## Appeal Decision

### **Appeal Ref: APP/R4408/W/23/3320901**

### **Car park, Old Mill Lane, Barnsley S71 1PJ**

Drawing
PROPOSED LAYOUT

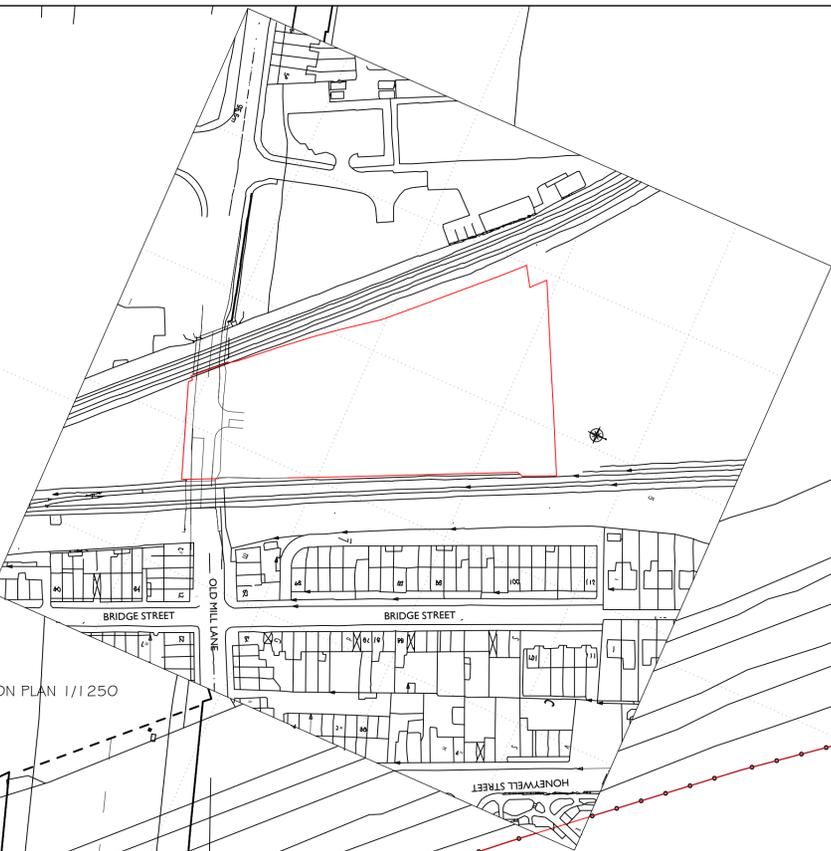
9. In terms of the site access, a junction feasibility plan was submitted with the application. Both the Council and the Peer Review have identified a lack of detail with this plan relating to the geometry of the proposed junction, which I agree with.

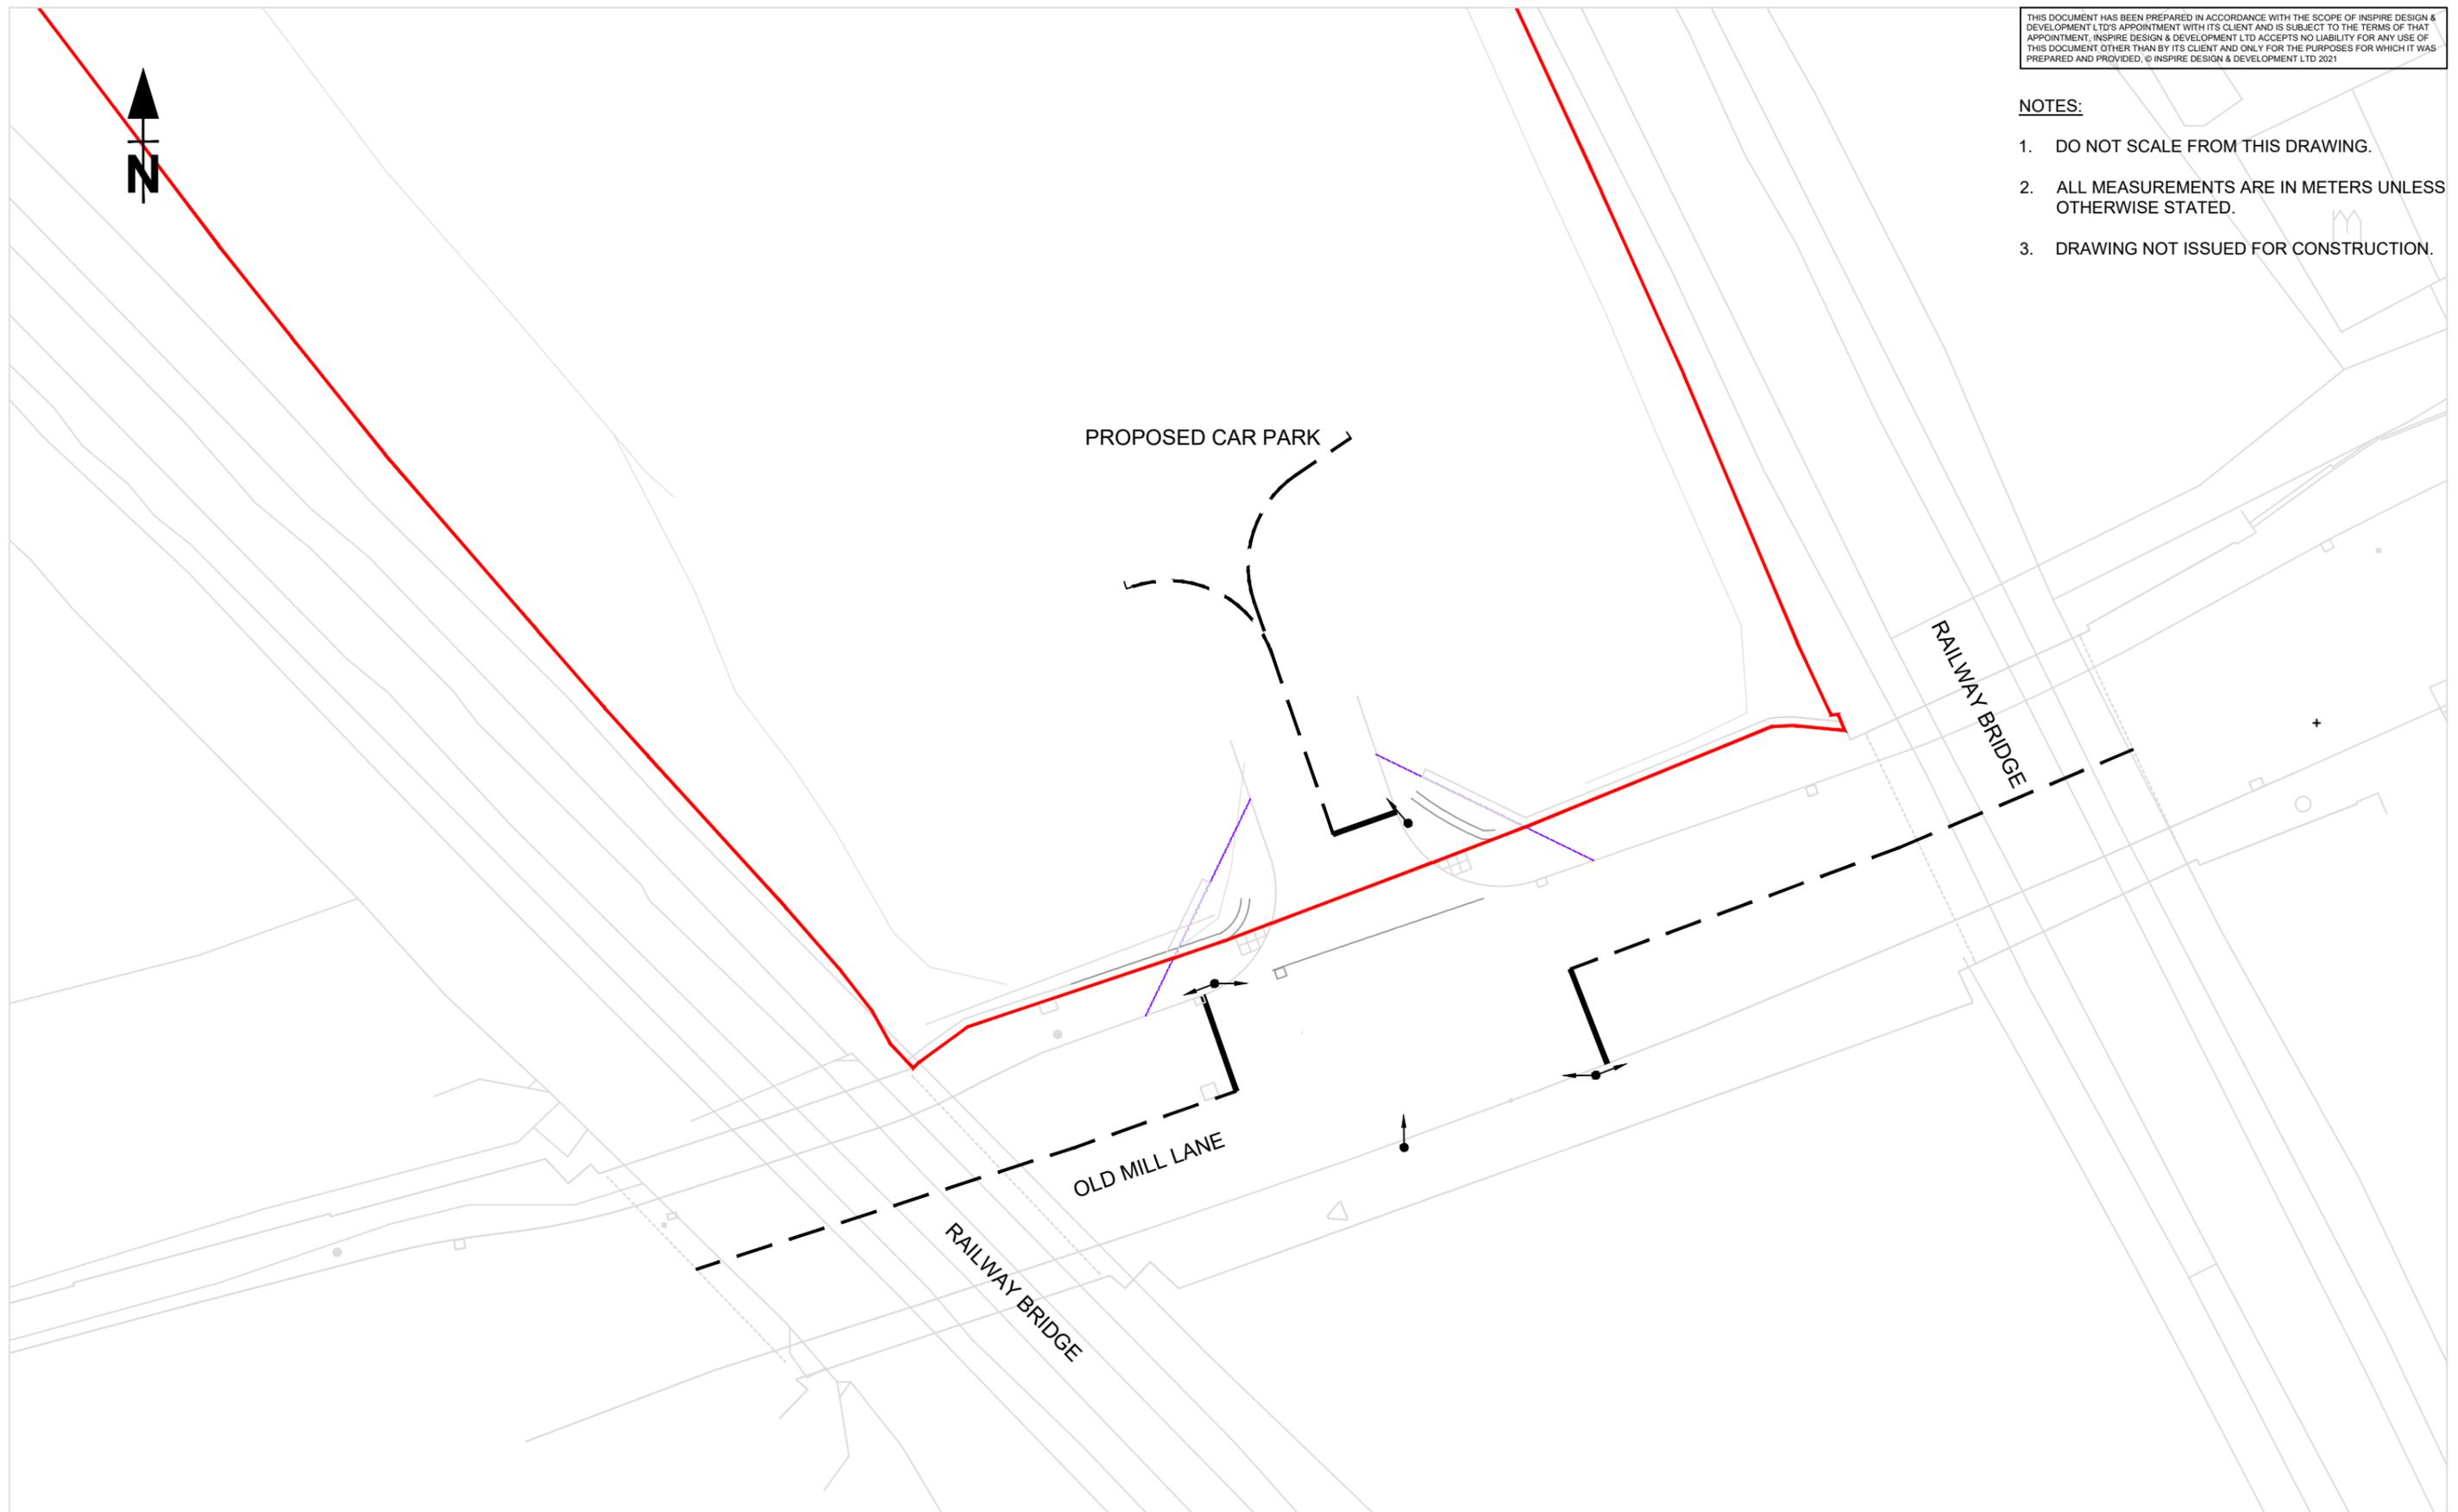
10. No swept path analysis has been included to demonstrate that a vehicle would be able to enter the site while one is waiting to exit. In my view, this should be confirmed given the importance of ensuring a free flow of traffic on what is a highly trafficked road that plays a significant role in the local highway network.

11. The Design Manual for Roads and Bridges (DMRB) sets out standards which apply to the design, assessment and operation of motorways and all-purpose trunk roads. Manual for Streets 2 (MfS2) makes it clear that the strict application of DMRB standards to non-trunk routes is rarely appropriate for highway design in built up areas. Nevertheless, the Peer Review highlights that MfS does not contain formal design guidance for signalised junctions and considers it appropriate to use DMRB CD123 for the design of such junctions. However, the Peer Review identifies that the junction feasibility plan does not confirm whether the proposed junction has been designed in accordance with DMRB CD123.

12. The submitted evidence identifies that it is not clear whether the proposed signal heads would be obstructed for approaching vehicles, nor is it possible to confirm for certain that the intervisibility between pedestrians and vehicles is appropriate. In addition, it is unclear how pedestrian access routes into the car park at the access point would be accommodated. To ensure that the proposal
